Application number: 2021/90609	
What is the application for?:	Erection of first floor extension over existing garage with roof terrace, single
Address of the site or building:	15, Far View Crescent, Almondbury, Huddersfield, HD5 8ER
Postcode:	HD5 8ER

User comments

PROPOSED SOUTH FACING ELEVATION
SCALE 1:50

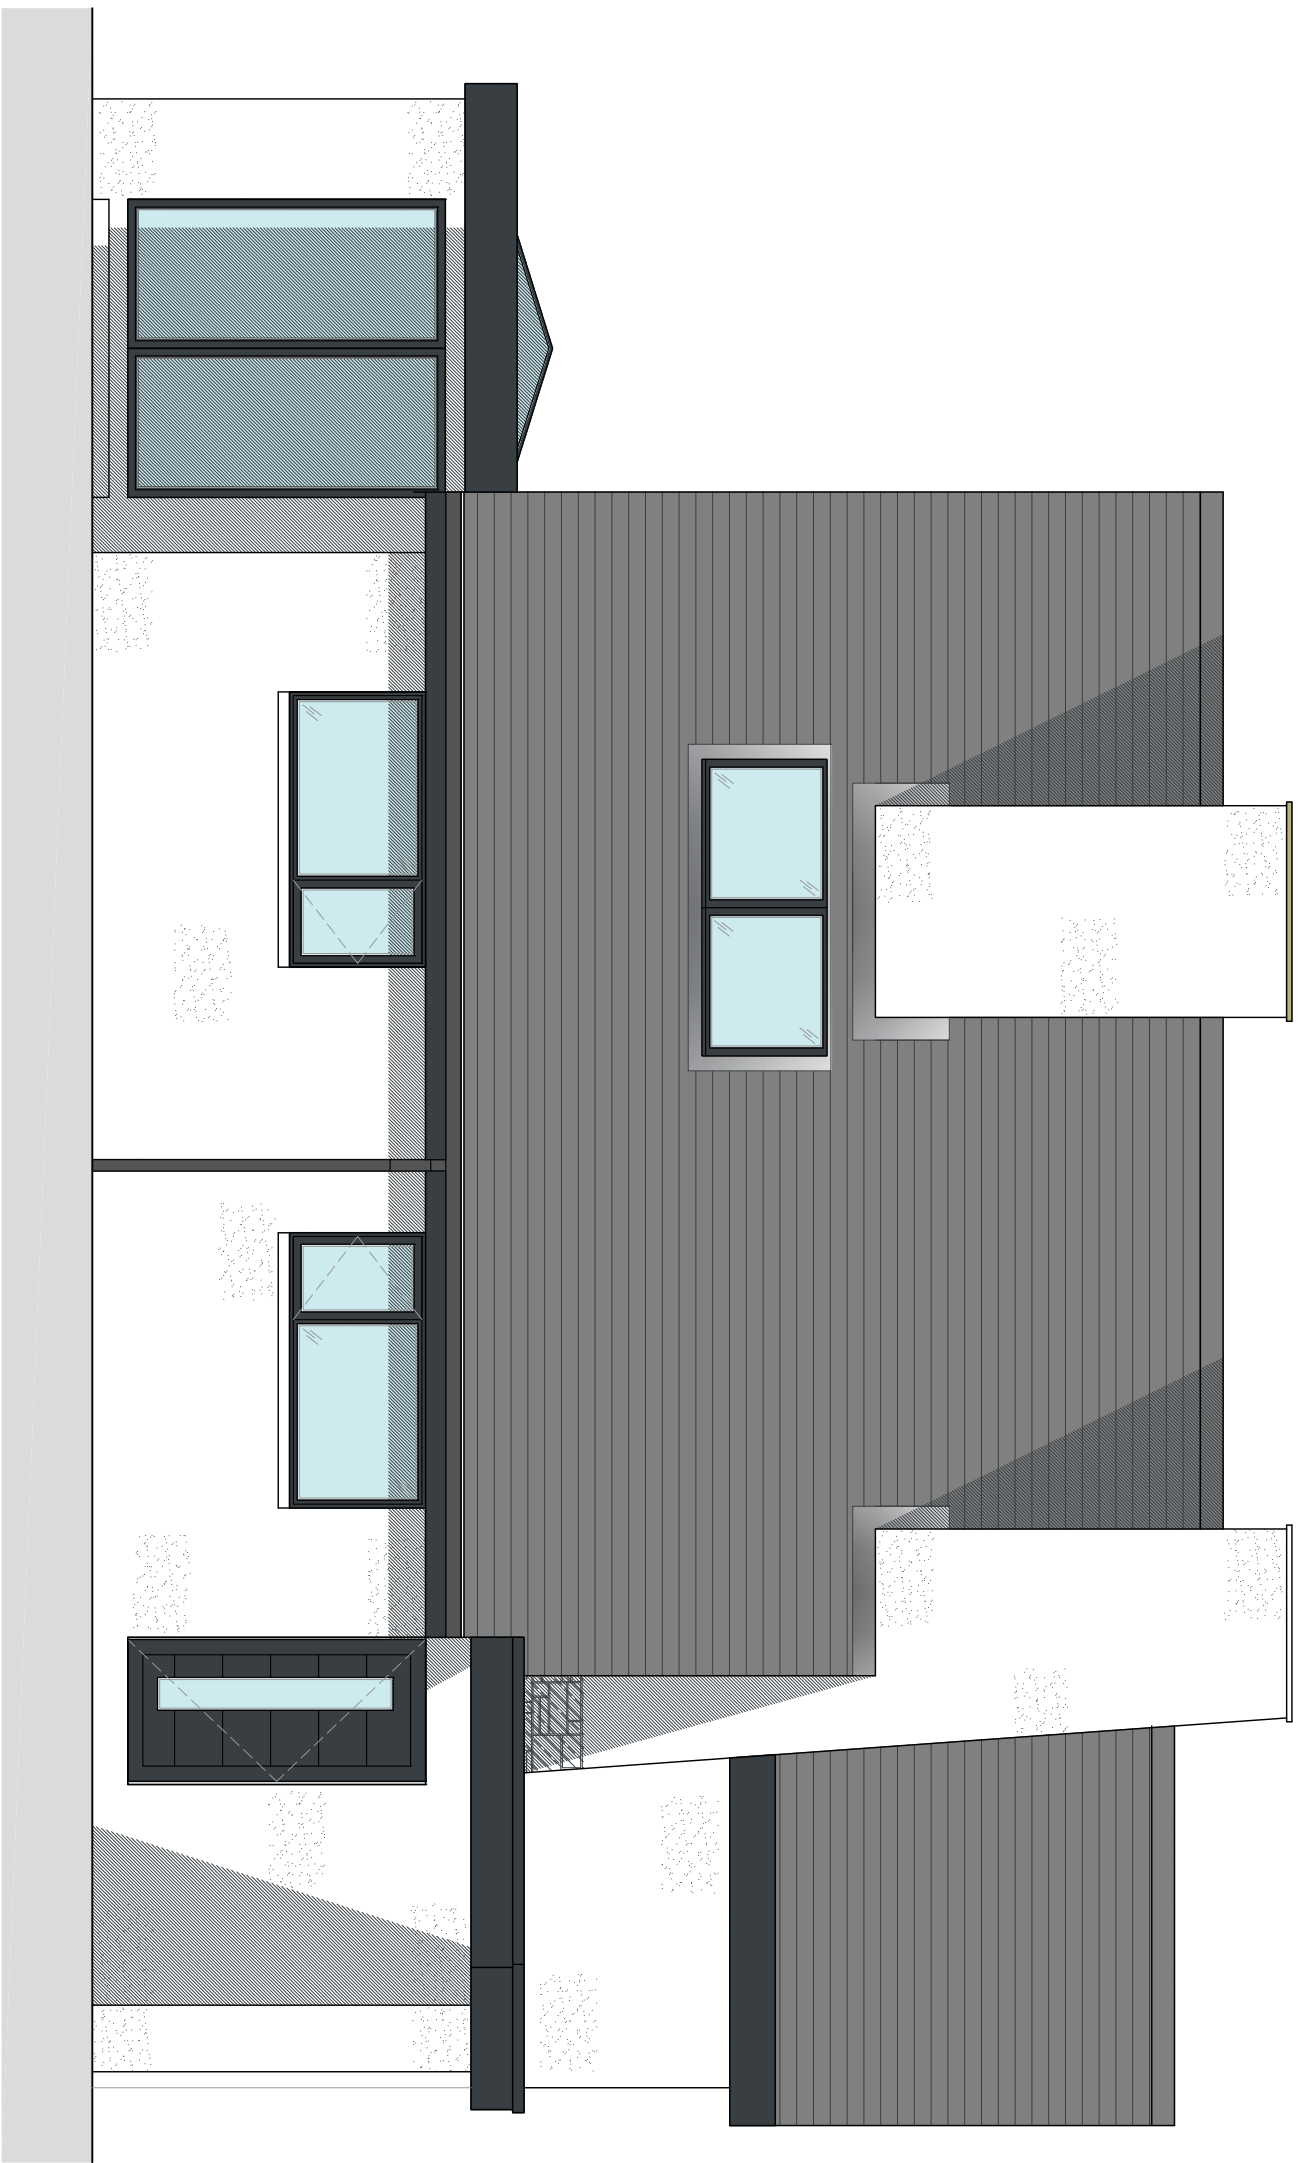
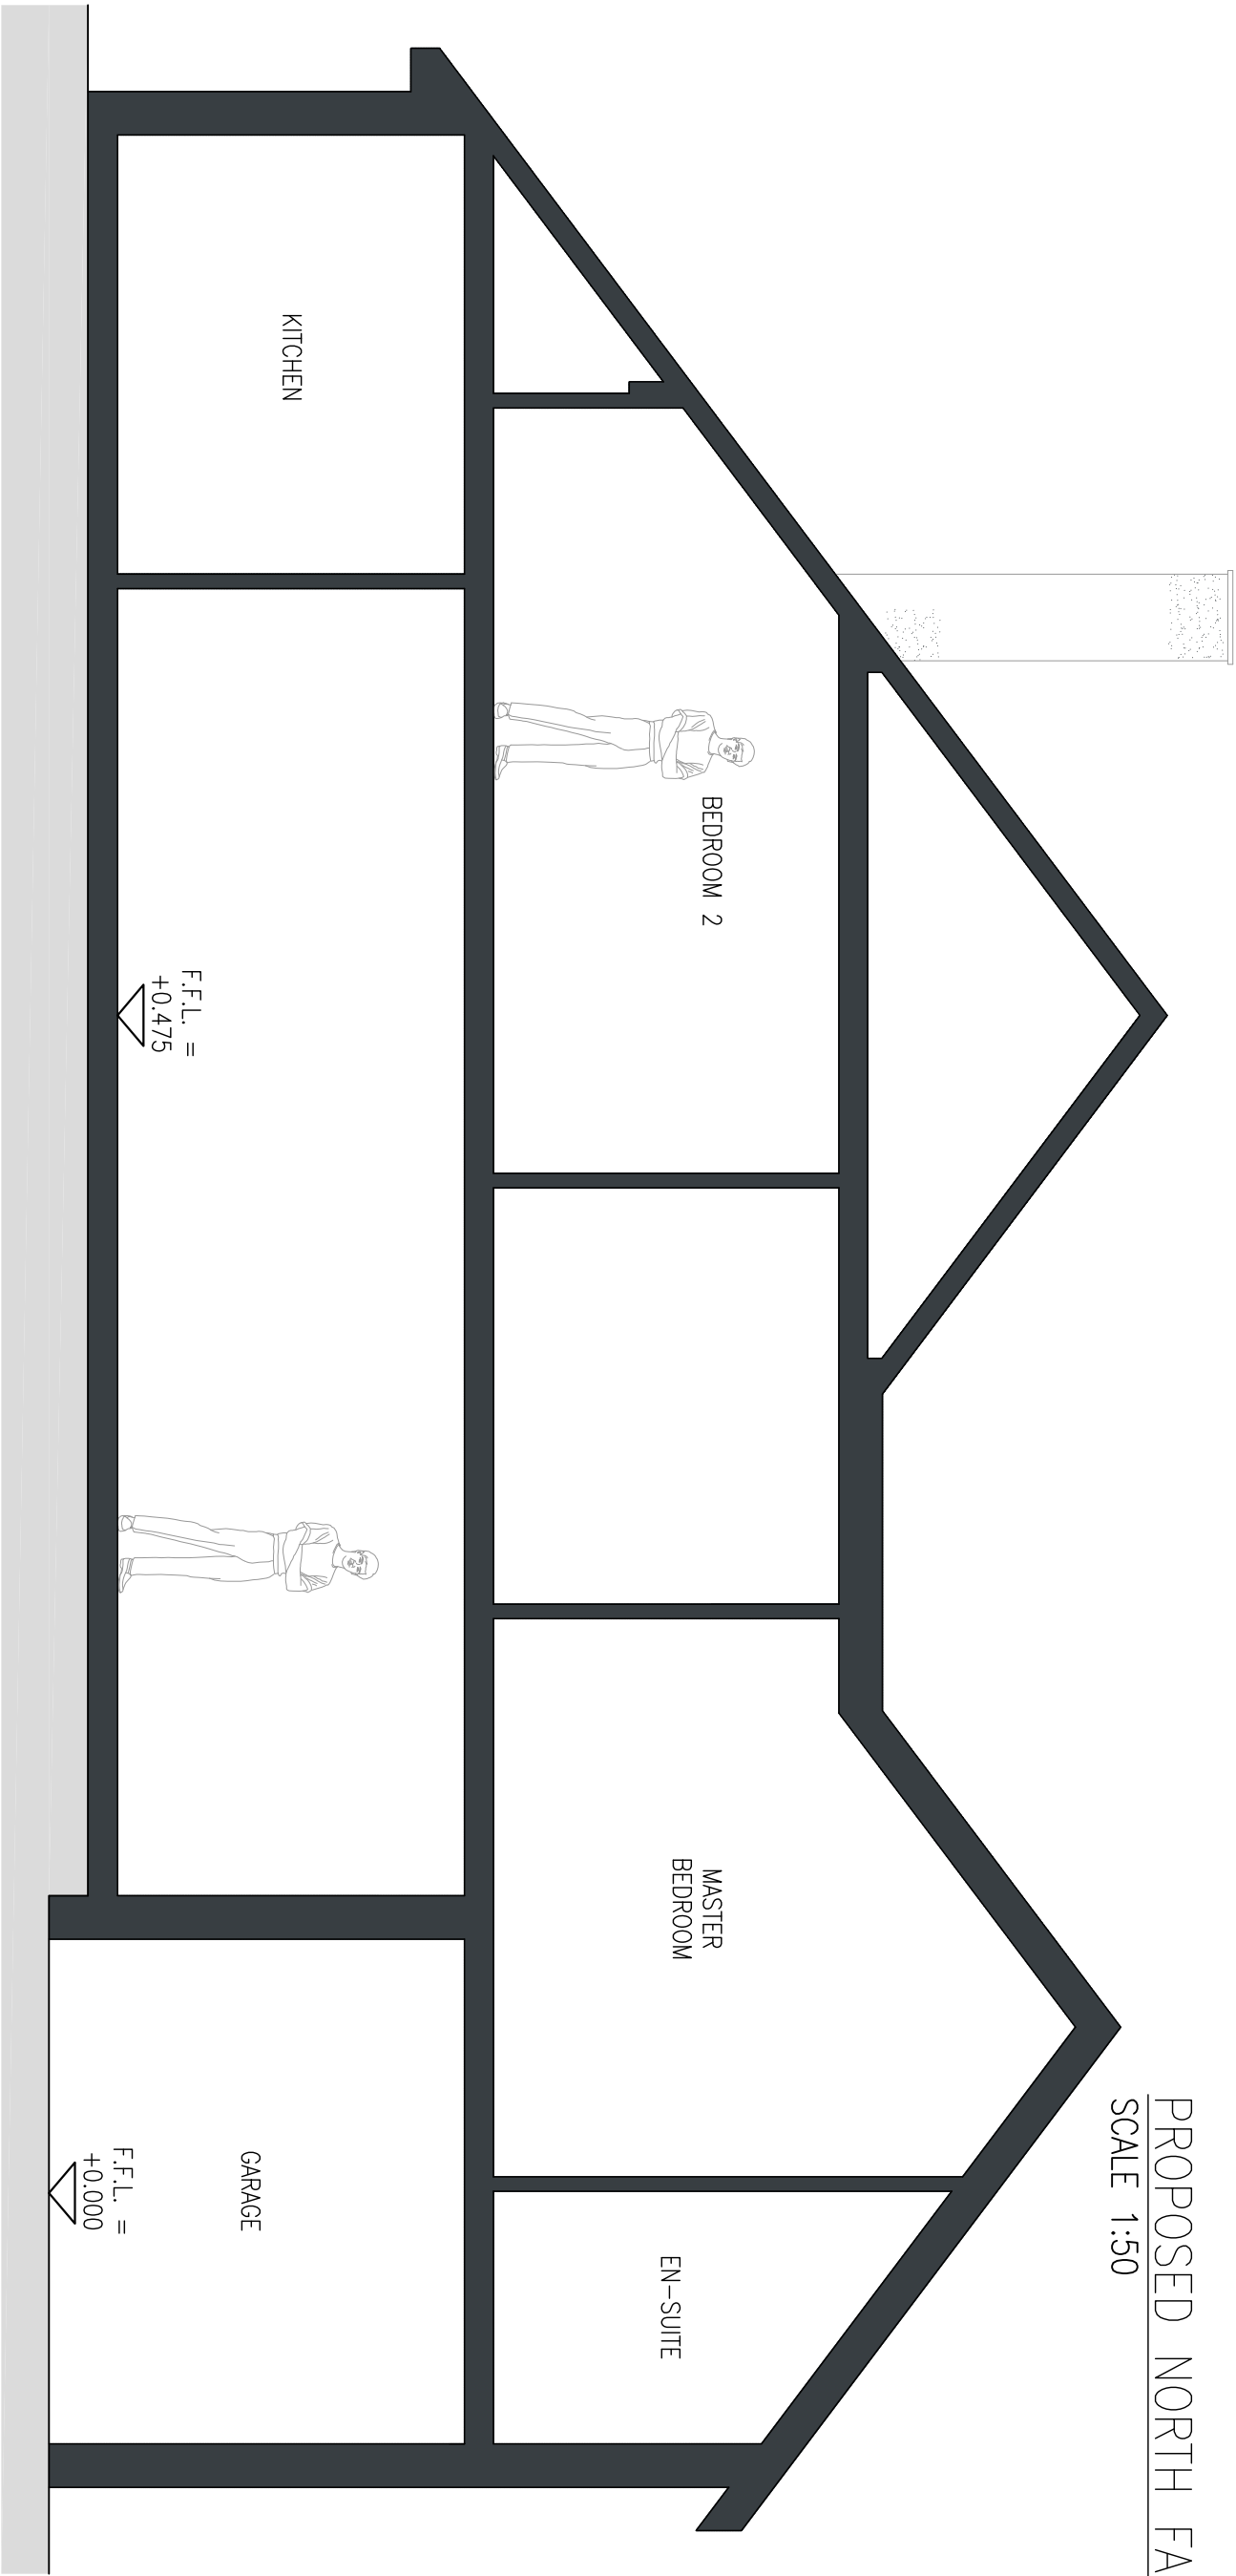
Type of comment: A general comment	
Do you wish your comments to be published on the website anonymously?	Yes
Amount of front facing windows, concerns about reflections/glare from sun rise into adjacent properties, this is already an issue from neighbouring property which also has many front facing windows.
